M25 junction 28 improvement scheme

TR010029

9.55 Written submission of Applicant's case put orally at Issue Specific Hearing 1 on Environmental matters held on 3 and 4 March 2021

Maritime House, Basin Road North, Portslade, Brighton, BN41 1WR  
Telephone: 01273 414515      www.redwoodpartnership.co.uk

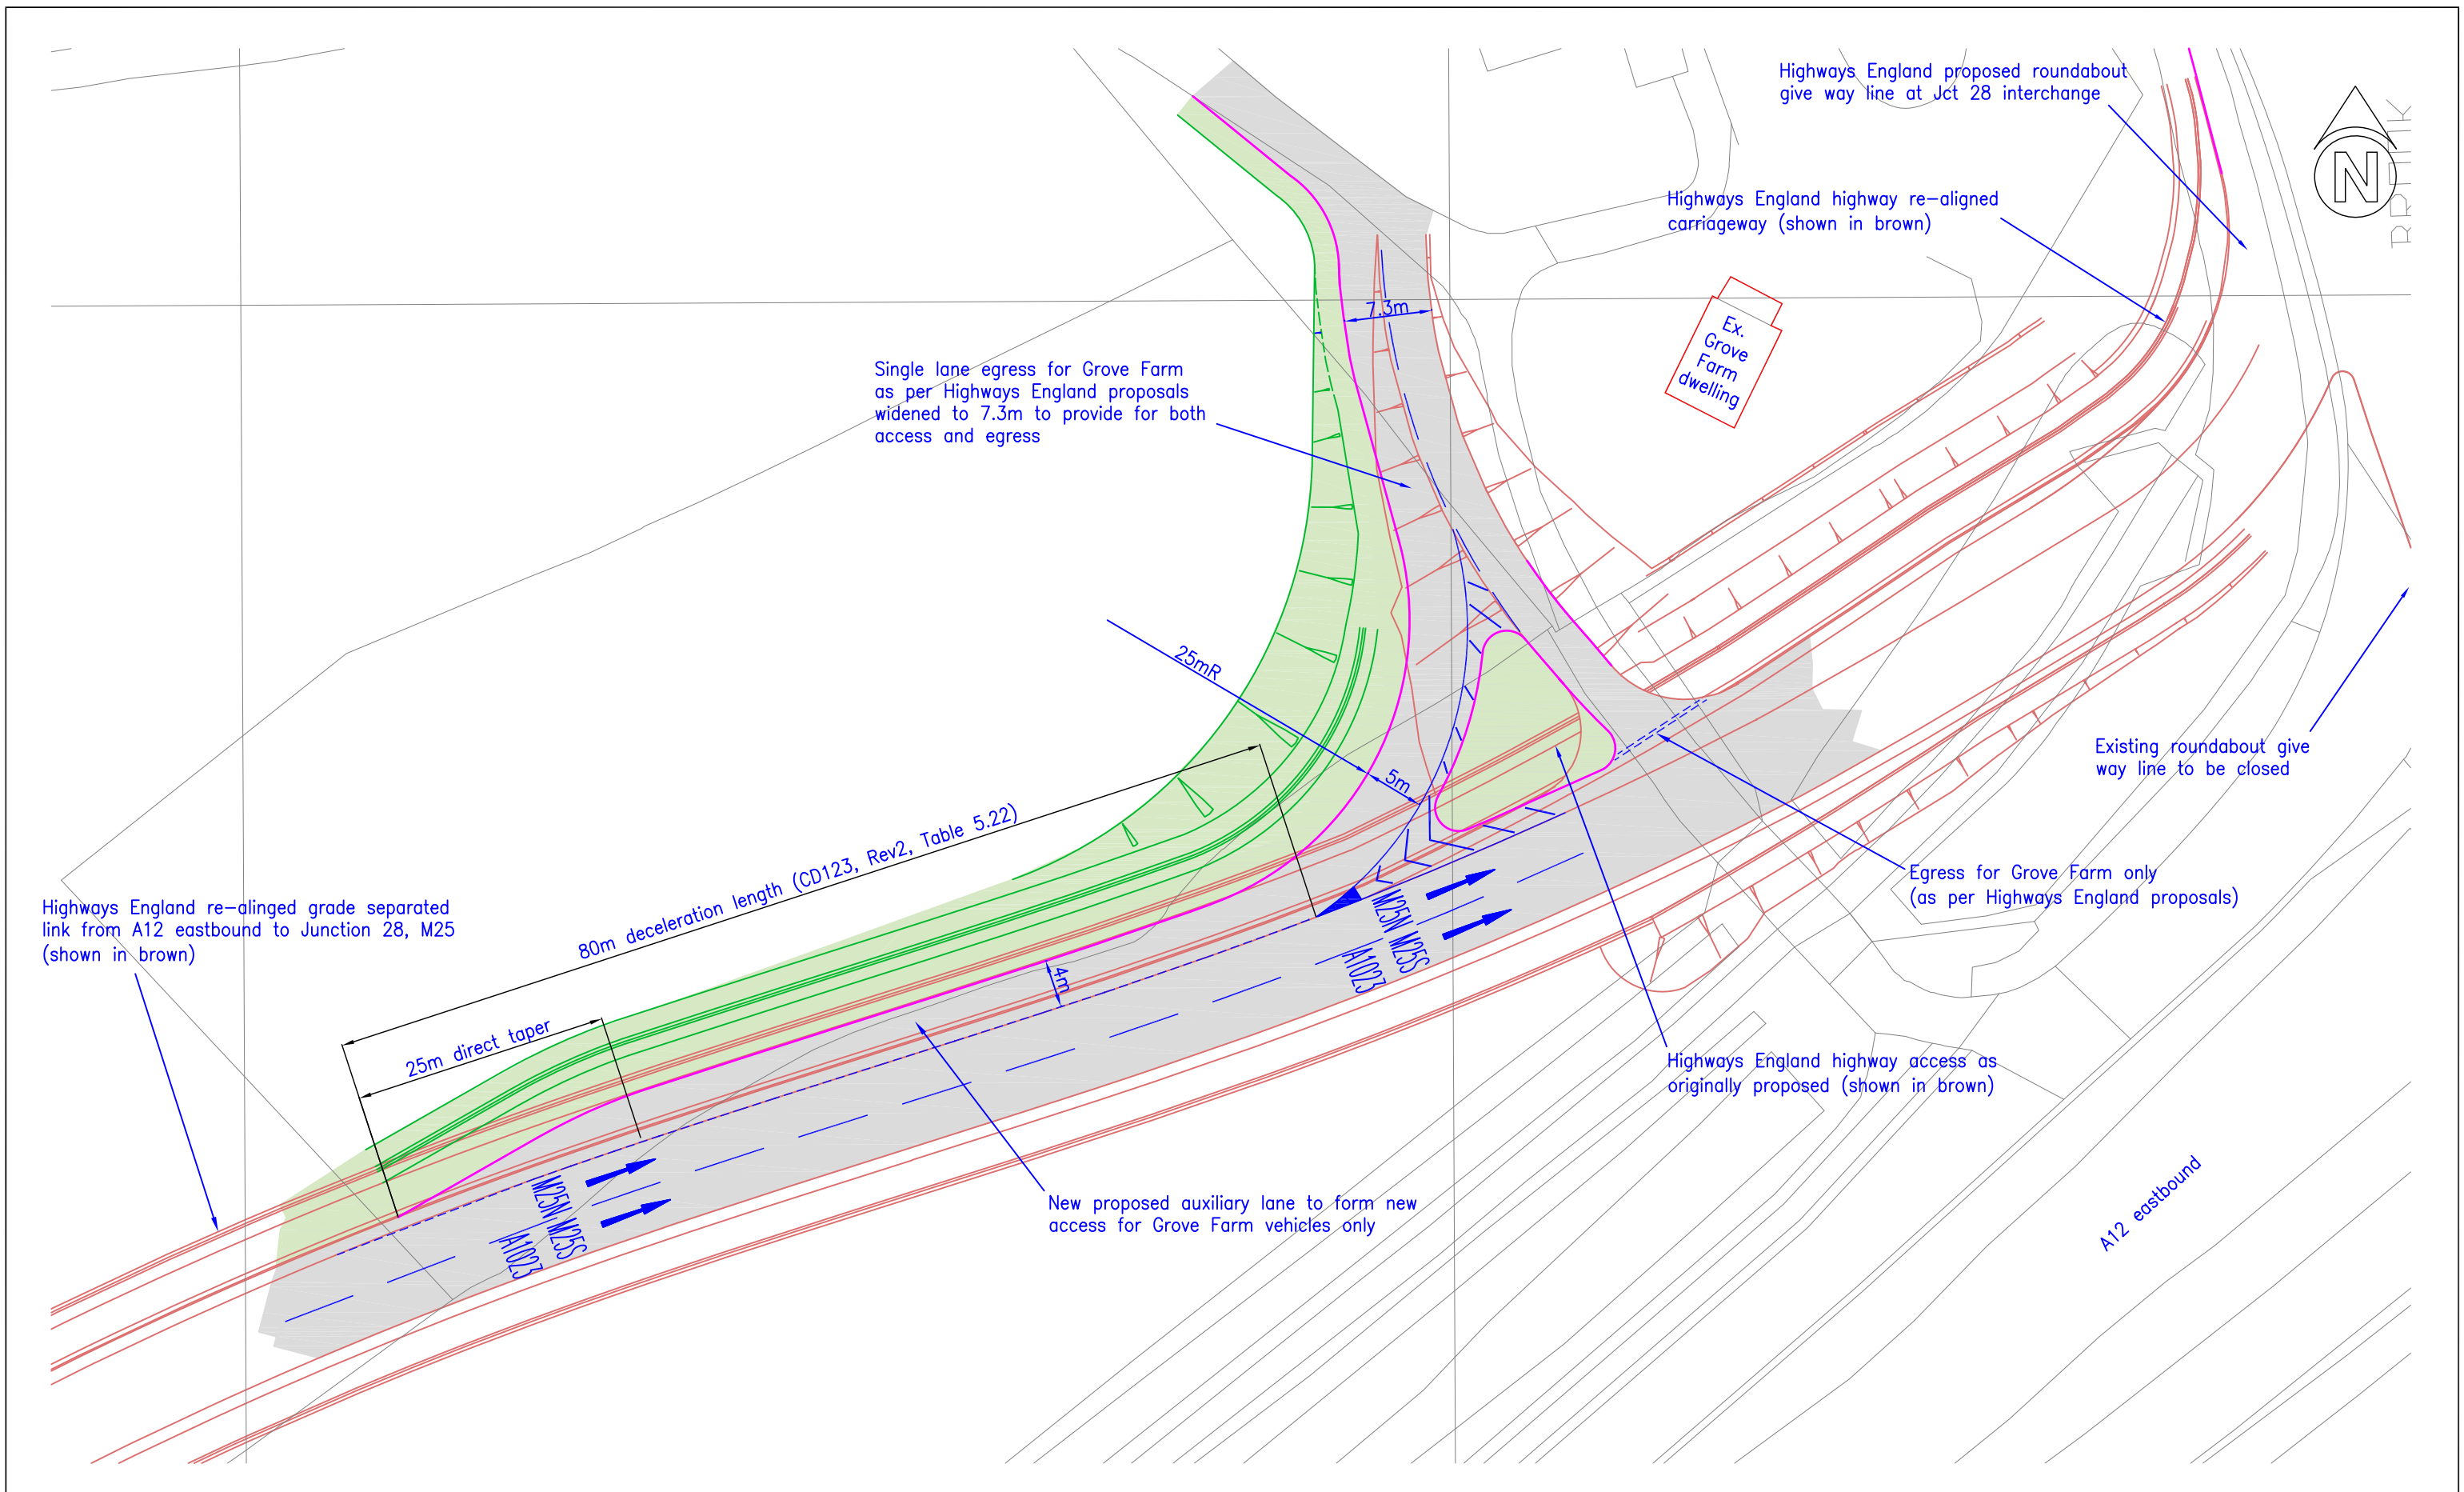
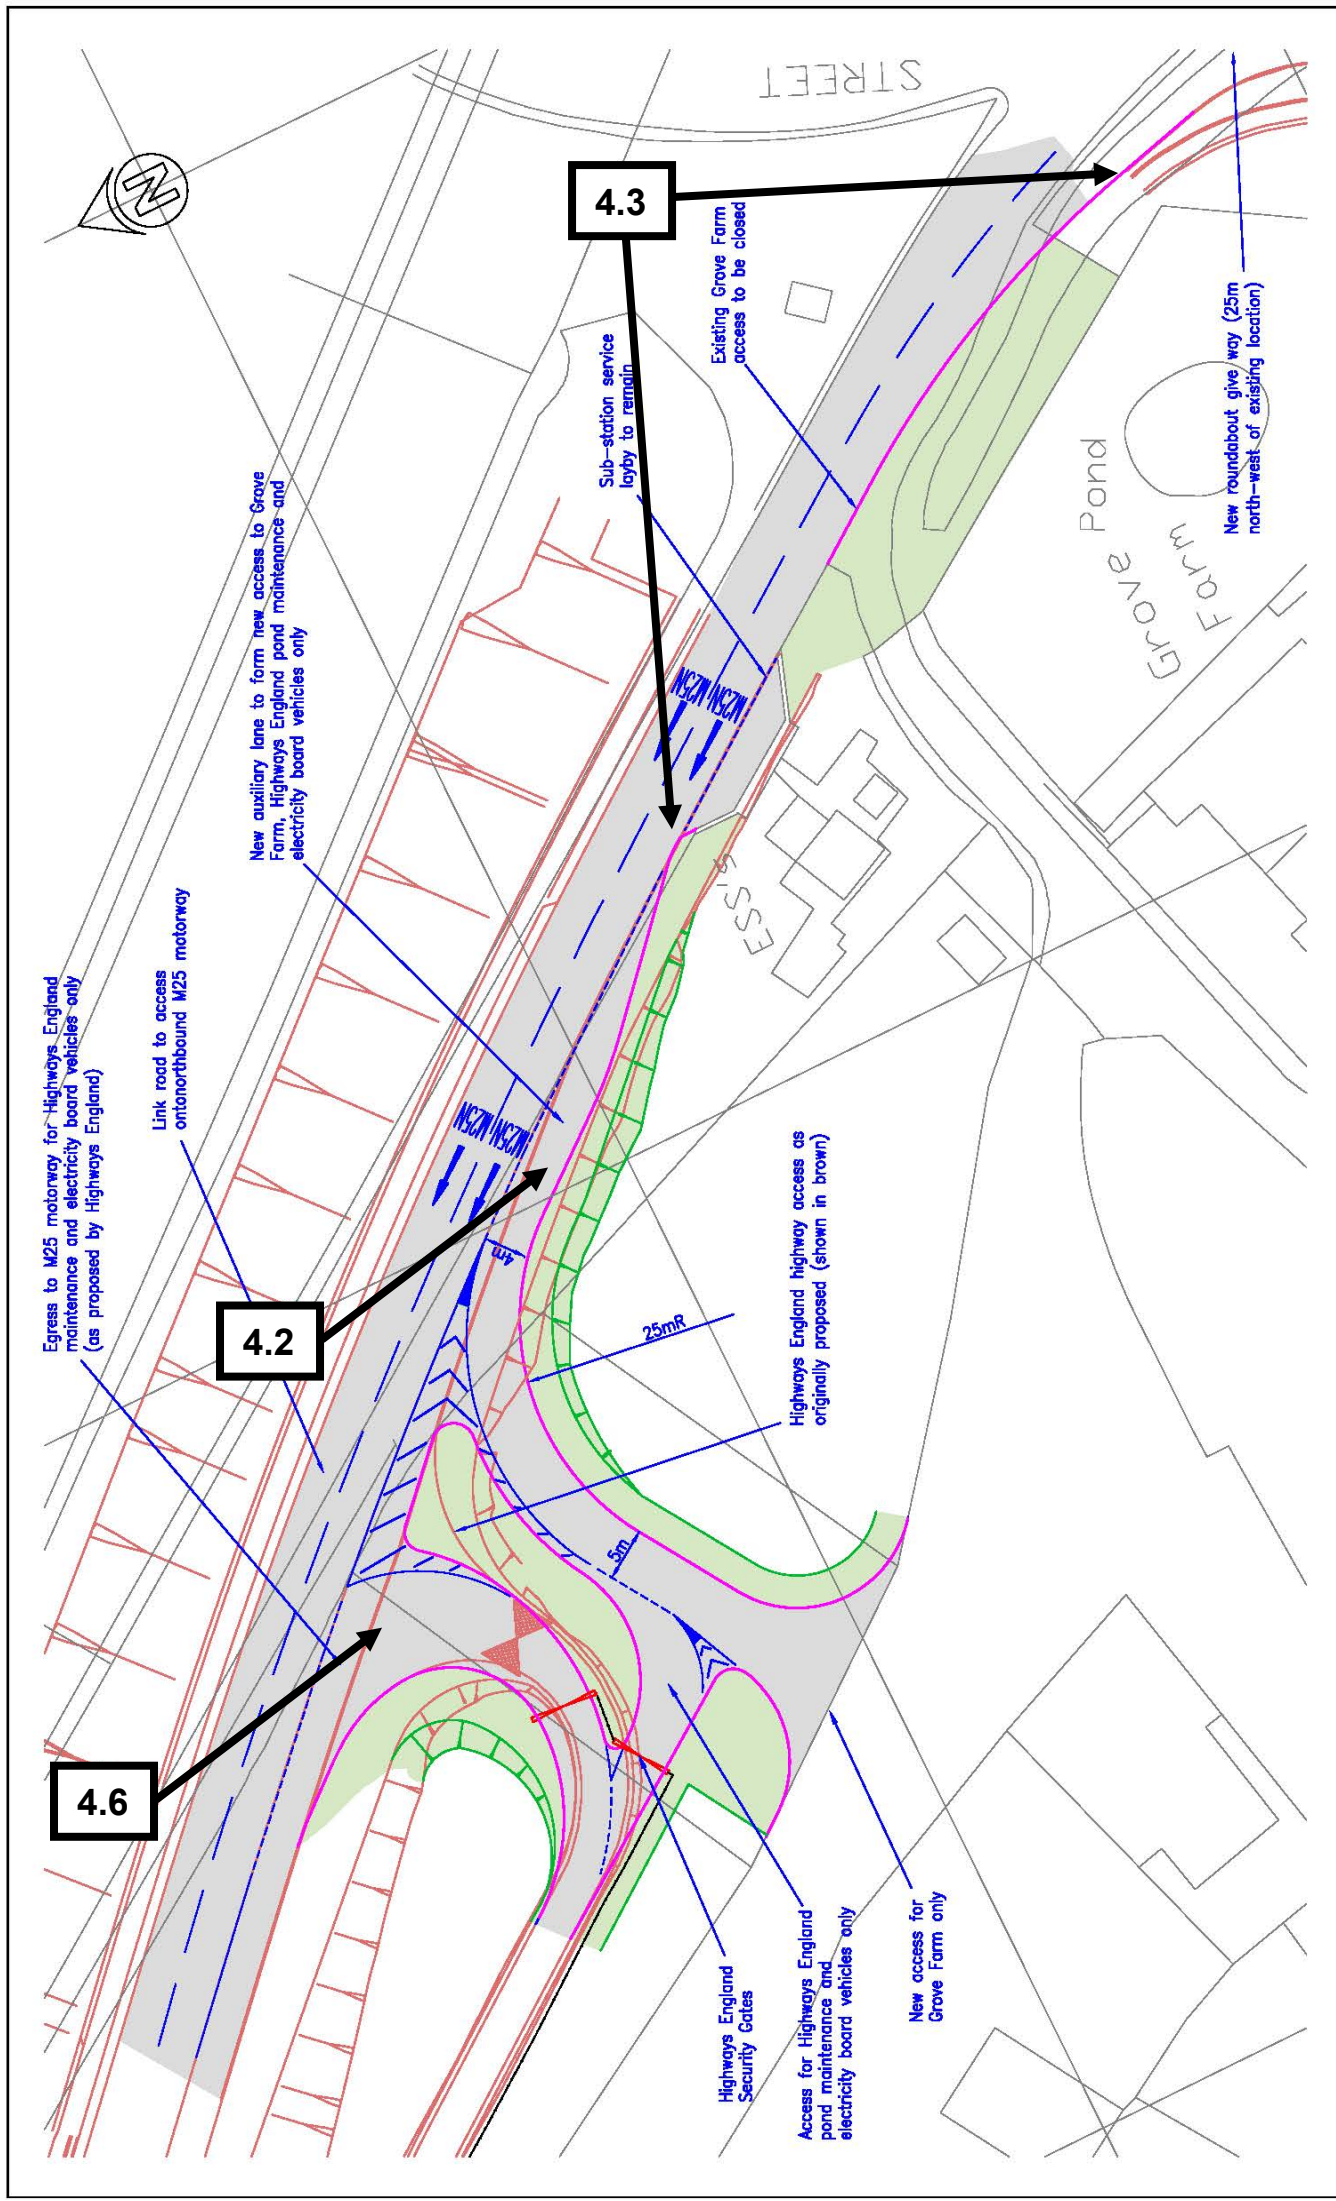
Agenda item 2.6 - Suggested alterations to proposed access to and egress from Grove Farm prepared by representatives of the Jones Family submitted at Deadline 2 [REP2-033].

- 3.1.59 Relocating the ingress further north along the M25 on-slip road places it where highway vehicles are accelerating towards the merge with the M25. SH explained that Highways England's road safety and operational safety specialists had raised concerns that such a relocation would be unsafe as vehicles braking to enter Grove Farm may cause collisions with vehicles accelerating to the M25. They also raised concerns that vehicles may exit Grove Farm via the ingress and turn right onto the slip road resulting in head-on collisions.

- 3.1.62 SH explained that a new ingress from the A12 would introduce an additional movement. This would create further hazards for through traffic as vehicles brake for the diverge where slip road traffic is travelling faster being further way from the stop line. This level of provision for a private access could also be confused with the M25 on slip. SH noted again that the Highways England's road safety and operational safety specialists have raised concerns that such a provision would be unsafe.

- 3.1.63 SH acknowledged that TfL had stated this and confirmed that direct accesses on slip roads are not permitted in the design standards. They would be departures from standards. Operational safety would be a material consideration in the departure approval review

- 3.1.64 SH concluded that moving the revised access from the M25 slip position as proposed by Grove Farm is less safe because vehicles are increasing their speed to merge with the M25. The existing access is close to roundabout so vehicles would be moving slowly.
